From: Jamie Brown [REDACTED]
Sent: 18 December 2019 11:48
To: Michael Eastham <Michael.Eastham@arun.gov.uk>
Subject: FW: Littlehampton: CEMP Rev D - LU/339/19/DOC and LU/340/19/DOC

Subject: RE: Littlehampton: CEMP Rev D - LU/339/19/DOC and LU/340/19/DOC

Wheel Washing Facility.

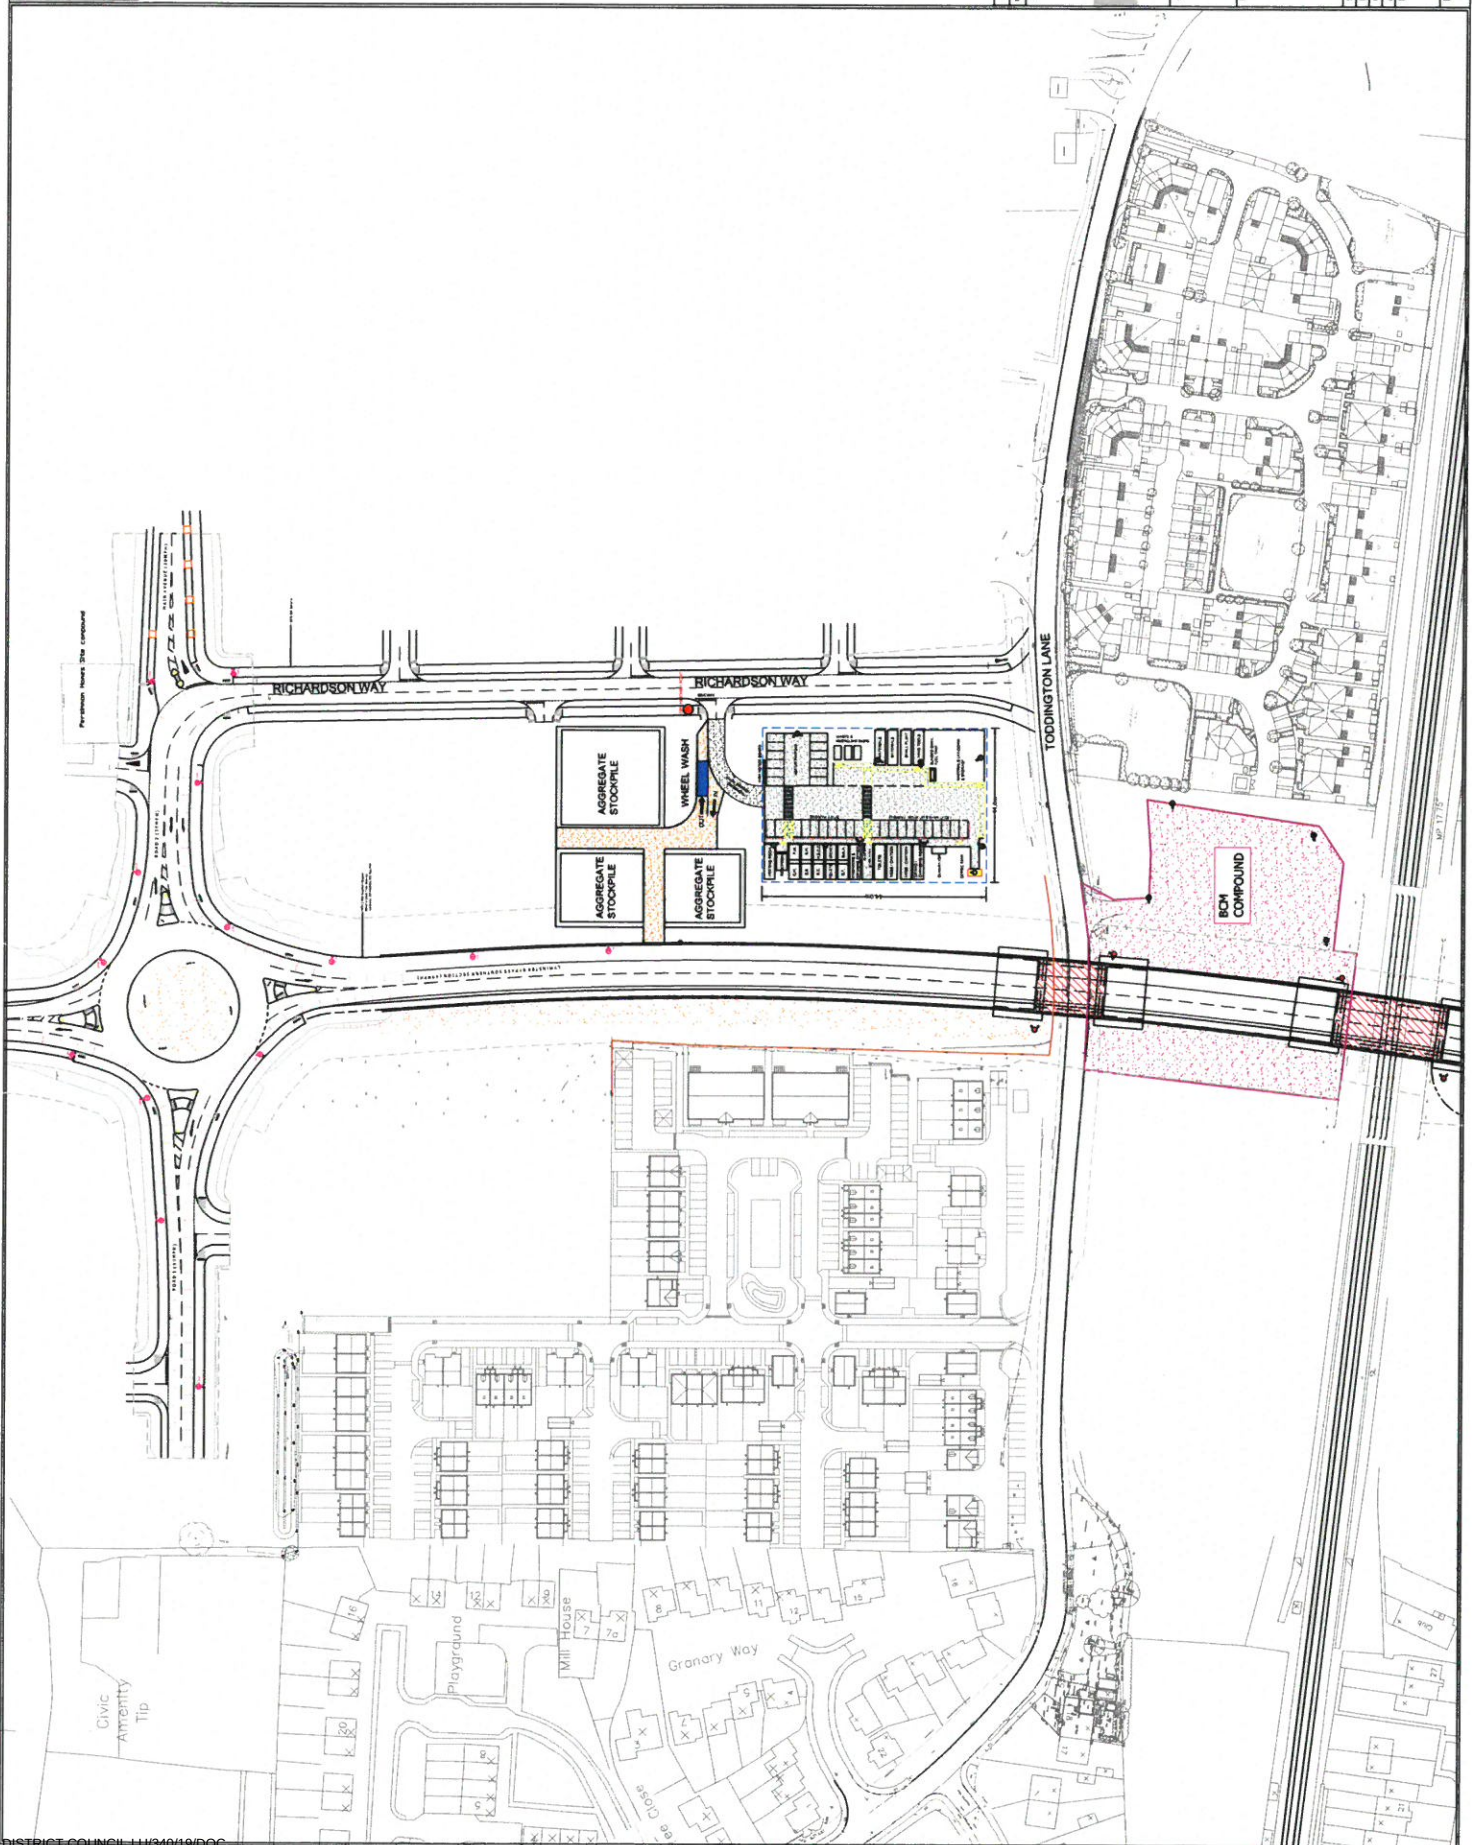
22 – is this OK with WSCC – might there be a need for automatic wheel-washing facilities, rather than just a man with a jet wash?

Also, not just the wheels to be cleaned – chassis and vehicle as a whole should have any mud that could get deposited on the road to be removed. Stones trapped between twin wheels to be removed too.

- Wheel wash facilities have been confirmed in this CMP. A commitment should also be made within the CMP to deploy a road sweeper as necessary on the surrounding local roads not just the site itself.

SHEET 2 of 4.

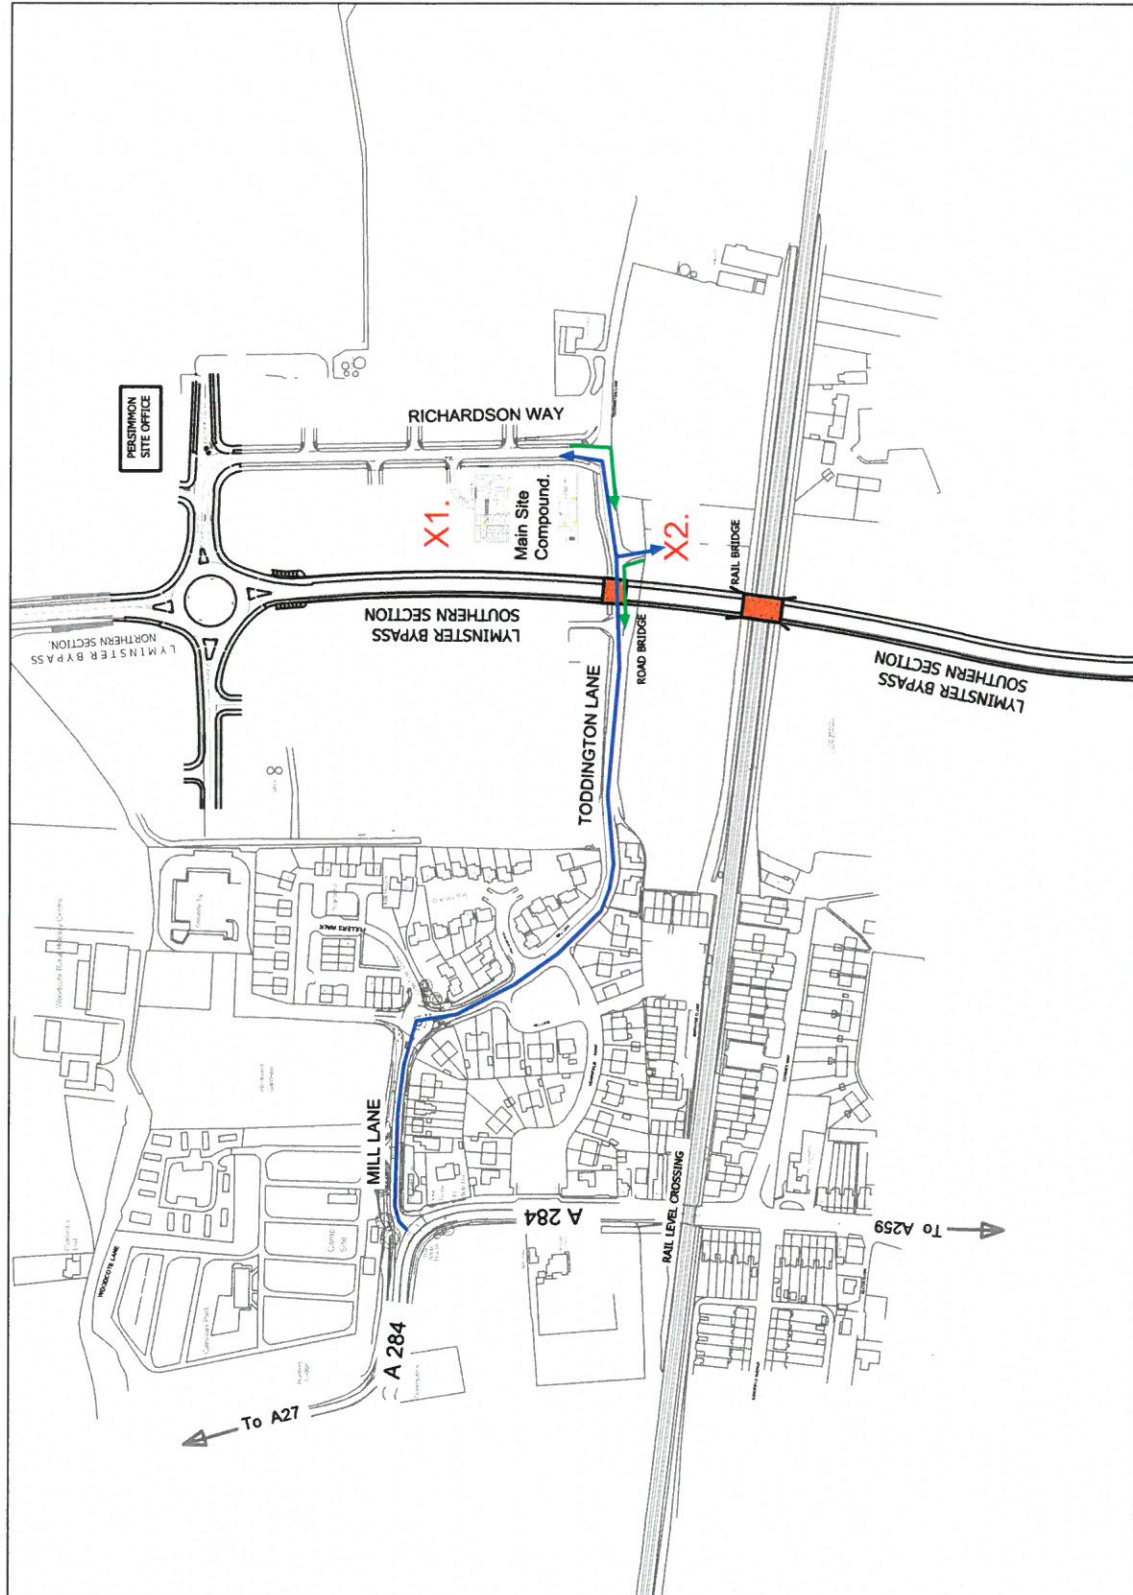
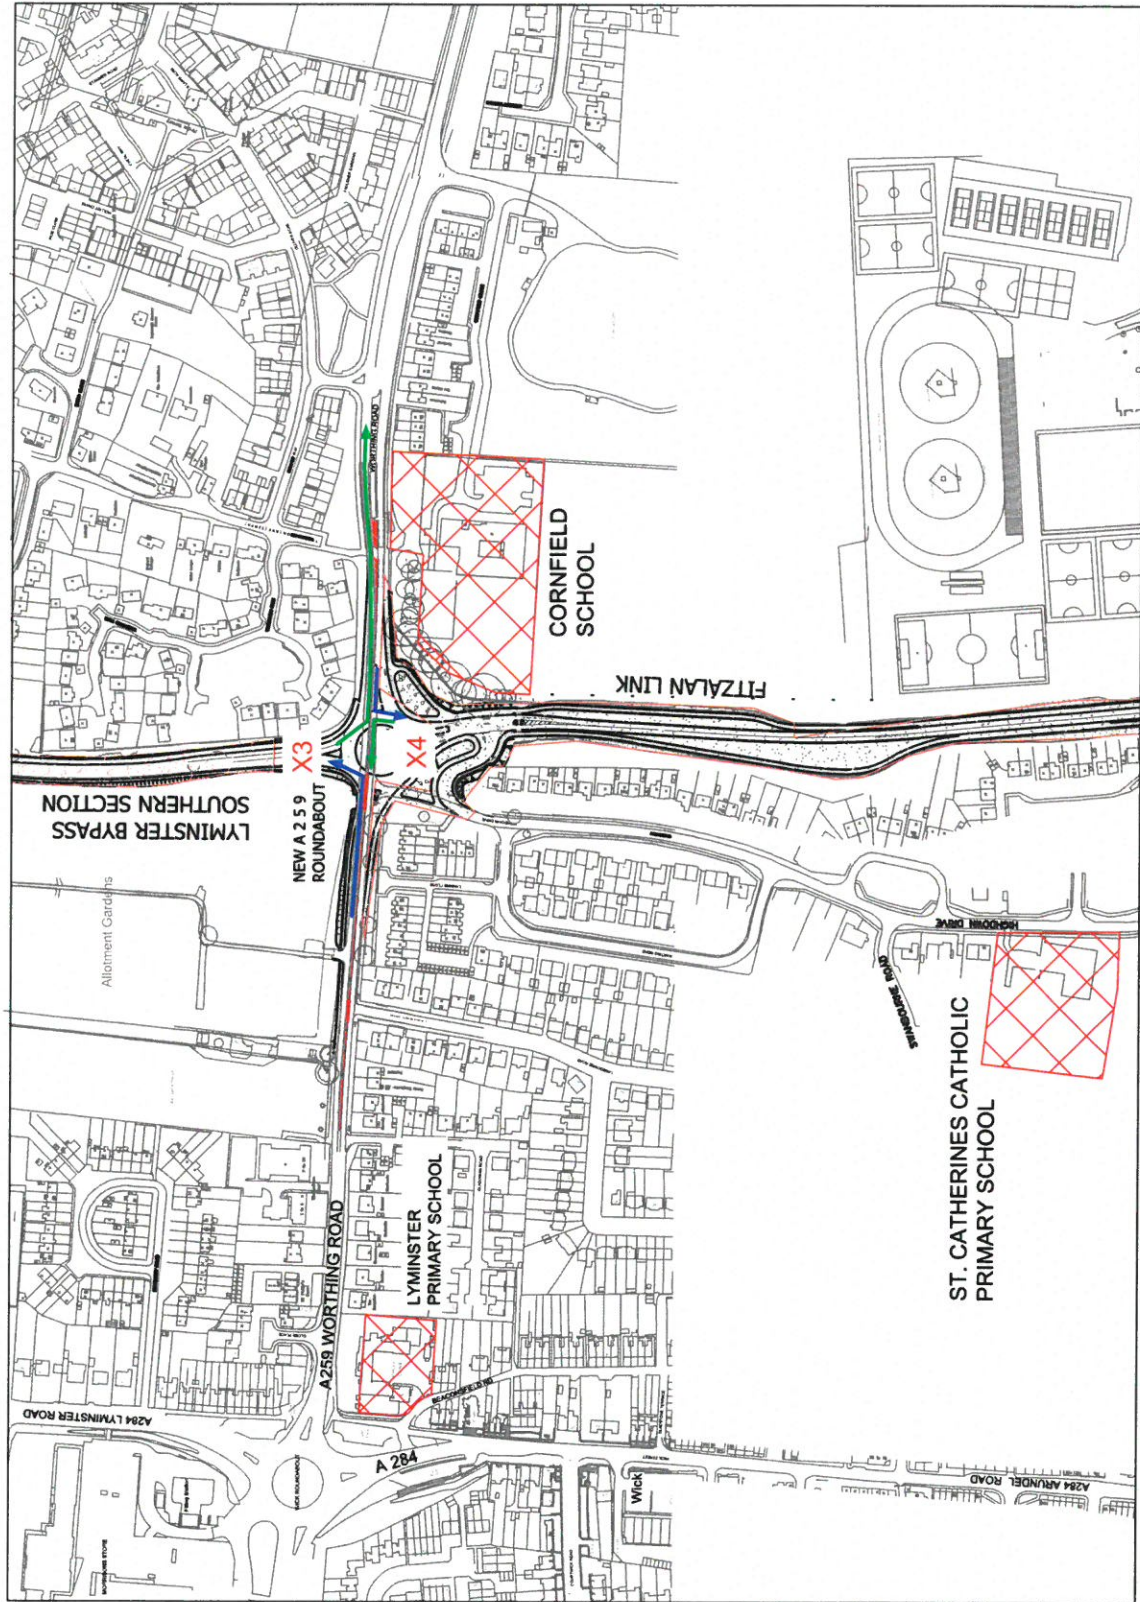
- Can the applicant confirm there will be no stacking on the highway during delivery times and that vehicles will load and un-load from within the site?
